SSD 6010 - One Residential Building (Student Accommodation) within Darling Drive Plot

2 August 2013

Summary

SHADOW DIAGRAMS: PERSPECTIVE, SHOWING THE PEAK, WINTER SOLSTICE

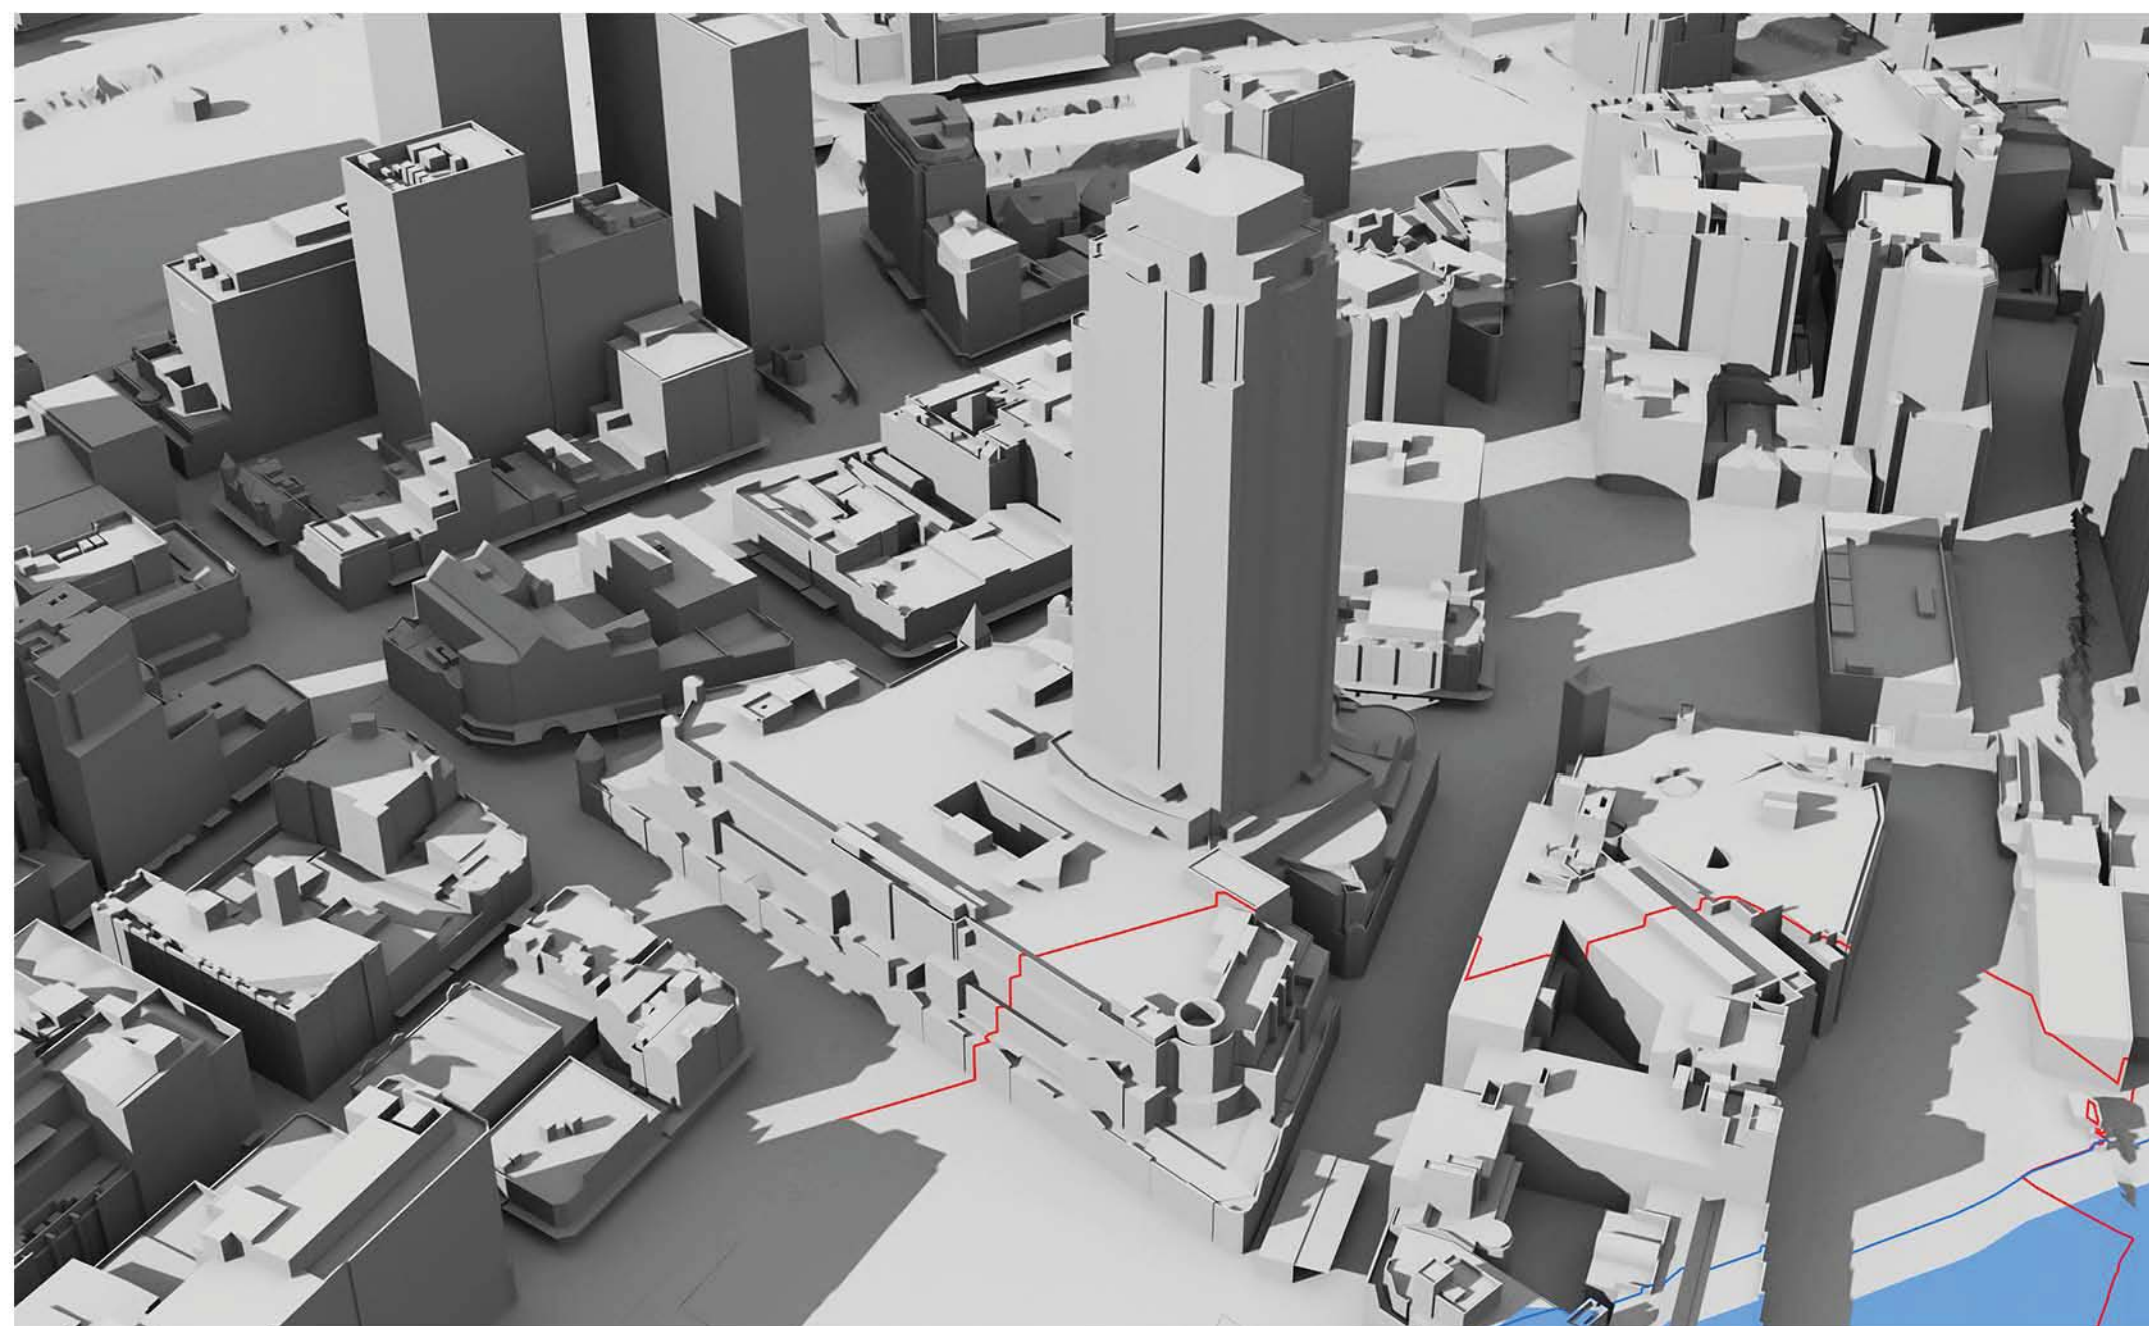
The proponent provides diagrams but fails to discuss the existing shadowing of the west façade of The Peak.

At 9am, 10am and 11am the west façade is totally in shadow due to other parts of The Peak building itself.

At 12pm there is still substantial existing shadowing on the west façade caused by the irregular shape of the west facade.

At 1pm the existing shadowing has been substantially removed, but not totally removed.

It can be concluded that some single aspect apartments on the west façade and some south-west dual aspect corner apartments currently receive less than 2 hours direct sunlight to habitable rooms and 50% of the private open space between 9am and 3pm on 21 June.

At 9am, 10am and 11am the west façade is totally in shadow due to other parts of The Peak building itself.

At 12pm there is still substantial existing shadowing on the west façade caused by the irregular shape of the west facade.

At 1pm the existing shadowing has been substantially, although not entirely, removed. However, overshadowing of lower levels of the west façade by the concept proposal parameter plan shadows for the N,NE and SE plots has already started.

By 2pm the existing shadowing has been totally removed. However, overshadowing of the west façade by the SSDA4 and SSDA5 buildings has appeared and risen further up the west façade than the concept proposal parameter plan shadows for the N,NE and SE plots, which is still present.

At 3pm, the proponent states correctly that 45-45% of the western façade is overshadowed by the SSDA4 and SSDA5 buildings.

It can be concluded that, as a result of combination of the proposed development with existing shadowing of the west façade, some single aspect apartments on the west façade and the south-west dual aspect corner apartments which currently receive less than 2 hours direct sunlight to habitable rooms and 50% of the private open space between 9am and 3pm on 21 June will suffer additional overshadowing. It is beyond our skills to count the number of such apartments. We note that the proponent has made no attempt to do so.
